Cockle Bay Park – Response to Agency Submissions

21 June - Midday

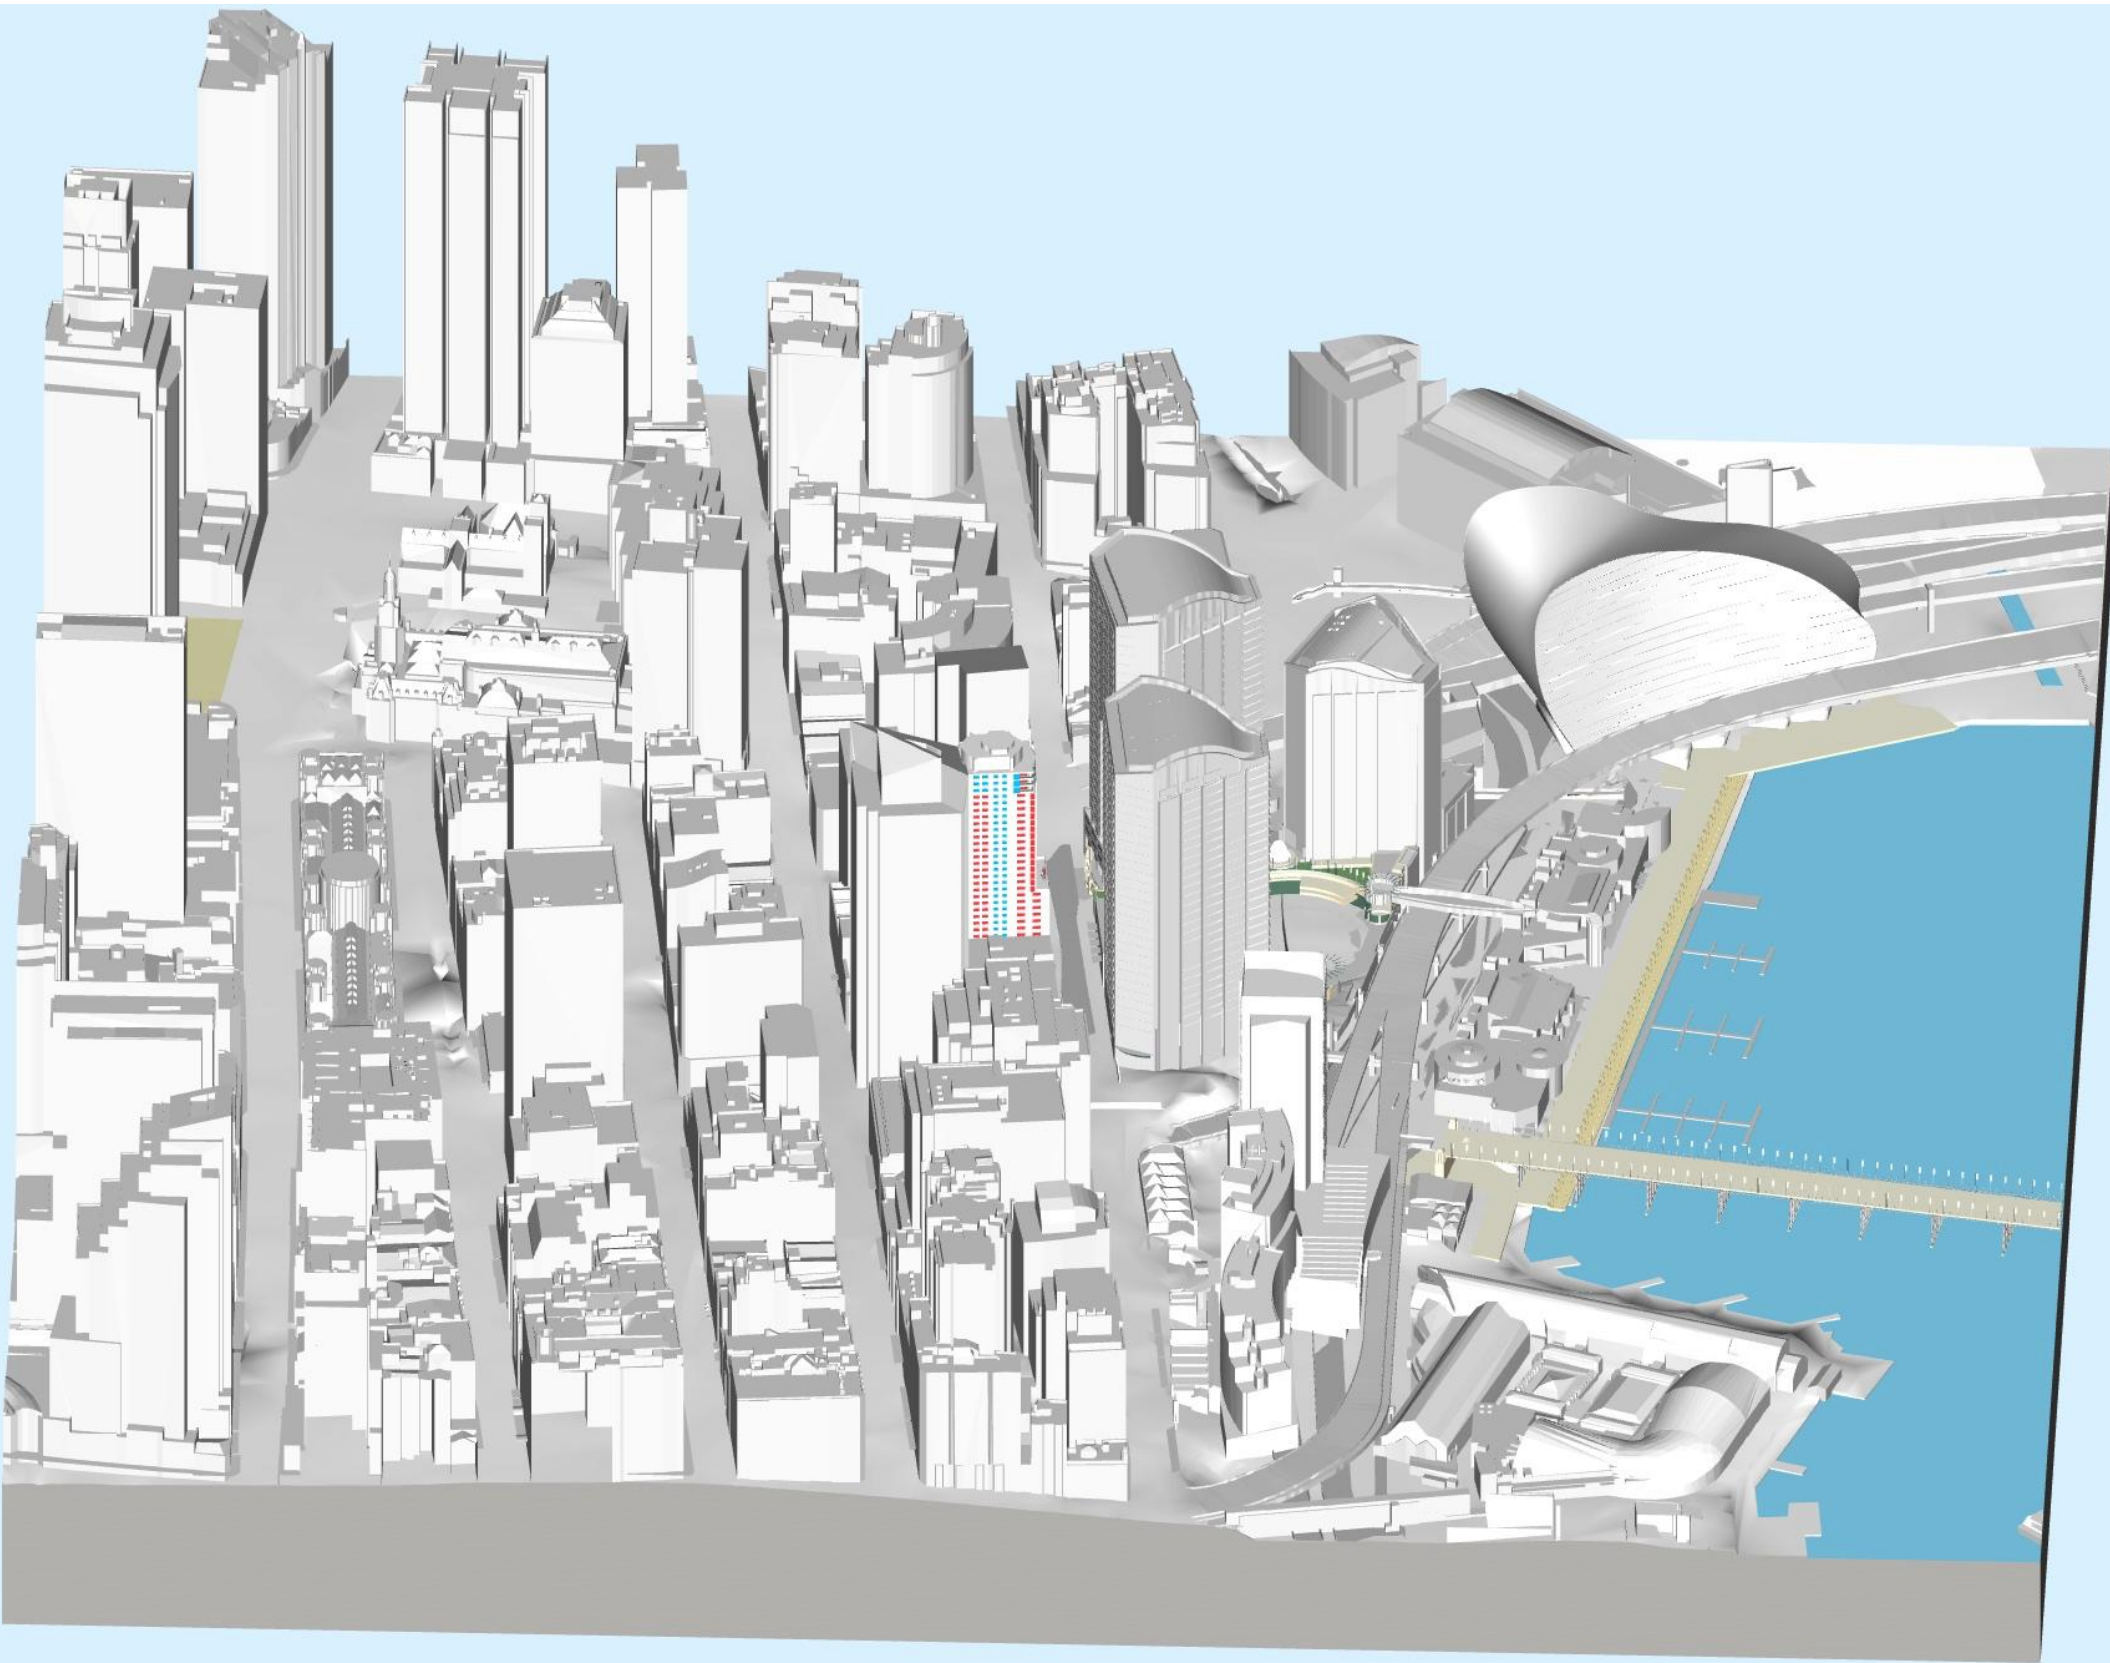
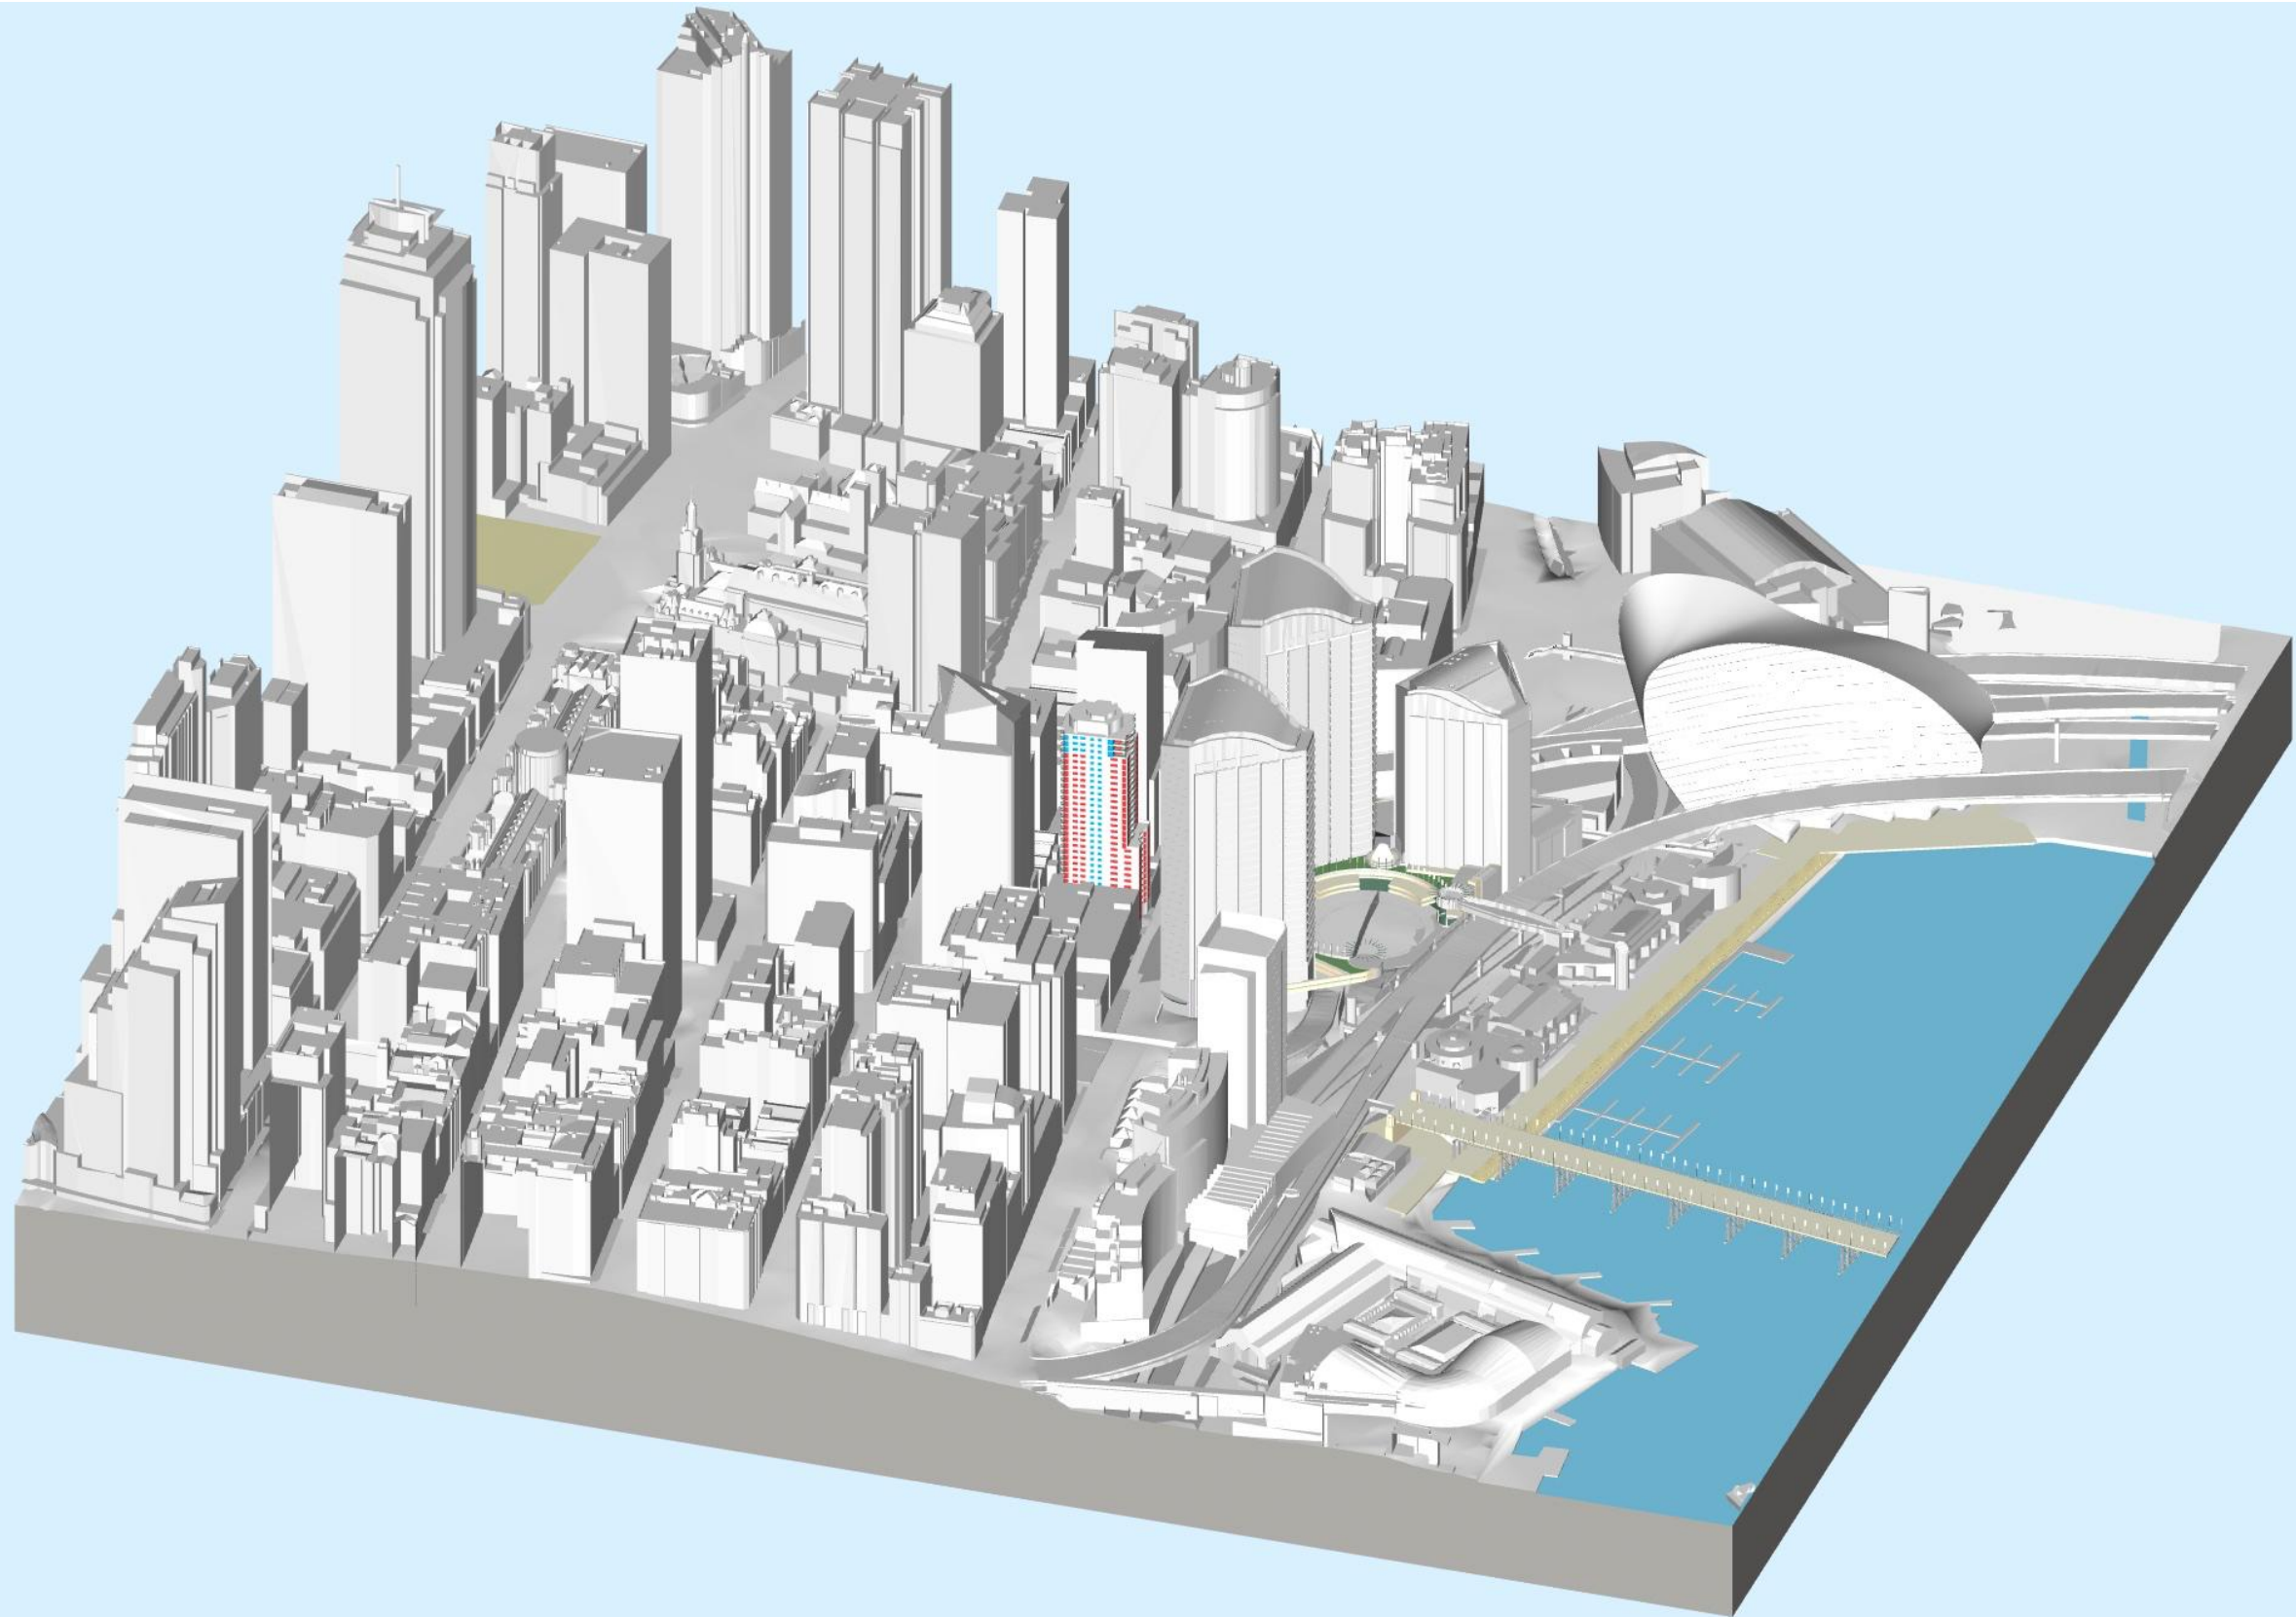
<i>Overshadowing</i>	
<p>Tumbalong Park will be impacted by overshadowing from the proposed development</p>	<p>One of the design principles of the Cockle Bay redevelopment is to avoid mid-winter overshadowing of the public domain areas of Tumbalong Park and the Children's playground. This principle is based on the precedent set by the Ribbon development approval.</p> <p>Two sun planes define the top of the proposed envelope, one at 12:00pm and one at 11:00am. The planes</p>

Item Raised	Proponent's Response
	<p>are generated from the roof line of the Ribbon development and project northward.</p> <p>To verify the sun planes solar studies and solar access analysis were undertaken. These studies demonstrate that the proposed development <u>does not generate any additional mid-winter overshadowing of Tumblong Park and the children's playground.</u></p> <p>Refer to the Solar Access Study included as part of Appendix C.</p>
<p>The proposed Town Hall Square will be impacted by overshadowing from the proposed development. The northern and eastern parts of the Town Hall Square will be most affected. The impacted times of the year will be from the beginning of April to late April and from mid-August to mid-September. During these times, the north-east corner will lose up to 25% of its direct afternoon sun.</p>	<p>Since the exhibition of the EIS the Concept Proposal has been further reduced and in-turn has reduced the amount of overshadowing predicted to affect the future town hall square. Updated shadow diagrams have been prepared that delineate between a shadow from the envelope and a shadow by a possible building within that envelope to understand overshadowing. The diagrams show there would be only minor additional shadowing to Town Hall Square that would be more than offset by increased provision of open space facilitated by the amended Concept Proposal.</p> <p>The Solar Access Study prepared by FJMT and included as part of Appendix C has compared the shadow impact to Town Hall Square from the original EIS and the amended Concept Proposal which shows there is an improvement (from 21 hours to 11 reduction) in sunlight over the course of the year.</p> <p>It is acknowledged that the amended Concept Proposal results in the potential for minimal overshadowing of the Square. Notwithstanding, the potential minimal overshadowing is considered reasonable in the circumstances for the following reasons:</p> <ul style="list-style-type: none"> • The draft Central Sydney Planning Strategy proposes to introduce additional “no additional overshadowing” control to the future Town Hall Square between 12pm and sunset (year-round). The draft CSPS has not yet been publicly exhibited and is therefore not a matter for consideration under S79C of the EP&A Act. • The period of impact is limited to approximately 3 weeks just after the autumn equinox and just before the spring equinox, for a period of 15 minutes (reduced from 20 minutes) with the maximum overshadowing impact (increase of overshadowing to the square) on the most affected days being 1.5 % (reduced from 2.9%), reducing to zero on other affected days.
